A46 Newark Bypass

Scheme Number: TR010065

**Statement of Common Ground With
The Environment Agency**

Regulation Number:	Regulation 5(2)(q)
Planning Inspectorate Scheme Reference	TR010065
Application Document Reference	7.21
Author:	A46 Newark Bypass Project Team, National Highways

Figure 10: Slough Dyke realignment – extract from AS-007 (General Arrangement Plans) Sheet 25005

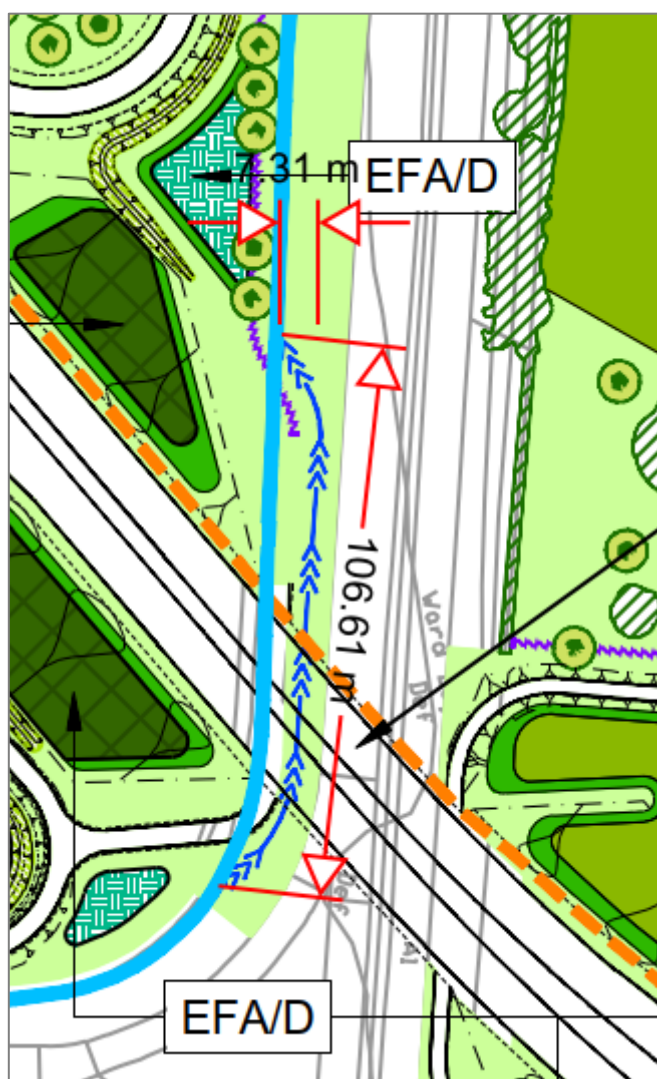
Issue No.	Issue	Document Reference	Environment Agency Position	National Highways' Position	Status	Date status confirmed
			No detailed drawings for the Slough Dyke realignment have been provided and the realignment has also not been represented within the hydraulic modelling undertaken. Update at Deadline 2: Within the most recent Hydraulic Modelling Technical Note (as submitted to us for review outside the Examination process), the Applicant has shown that the realignment of Slough Dyke has now been tested within the hydraulic model and confirms no impact on flood risk. No further action is required by the Applicant with regards to testing the Slough Dyke realignment within the hydraulic model. The Hydraulic Modelling Technical Note should be included as appendix of an updated FRA to be submitted as part of the DCO application. While the Applicant has provided sufficient evidence to us to demonstrate that the realignment of Slough Dyke will not have an adverse impact of flood risk, we are still awaiting detailed plans of the proposed river channel in situ. The Environment Agency requires satisfactory cross- sectional plans of the channel and drawings of the channel connecting to the existing channel in order to full resolved this issue. Once a satisfactory revised FRA and plans as mentioned above have been submitted as part of the DCO application, we will be able to resolve this issue. Update at Deadline 4: The Hydraulic Modelling Technical Note as referred to in our WR has now been submitted into the Examination at Deadline 3 [document ref. REP3-034]. This satisfactorily demonstrates that the realignment of Slough Dyke has been tested within the hydraulic model and confirms no impact on flood risk. However, we are still awaiting further detailed plans to clarify the proposed realignment. We acknowledge the Applicant's comments in response to our WR on this issue. However, the issue has since been covered at ISH3 (agenda Item 4 – please see above comments) and note the Applicant intends to provide us with the details we require as part of the DCO, which differs from their proposed approach in their response to our WR. We are satisfied the resolution of this issue is moving forward and we will provide an update following further engagement with the Applicant.	submitted during the DCO Examination will be appended to the Flood Risk Assessment [APP-177] as appropriate before the closing of the Examination. The Applicant will complete the detailed design of the Scheme following the grant of a DCO for the Scheme. The Applicant has engaged with the Environment Agency regarding the Slough Dyke realignment at flood risk meetings on 05/09/24, 17/10/24 and 27/01/25, providing further details on the proposed plans. On 27/01/25, the draft detailed plans, including a cross-section, for the realignment were discussed with the Environment Agency. At this stage, it is suggested that securing the Environment Agency as a consultee on the design of the Slough Dyke realignment is appropriate. The Applicant welcomes the Environment Agency's further comments on this item.
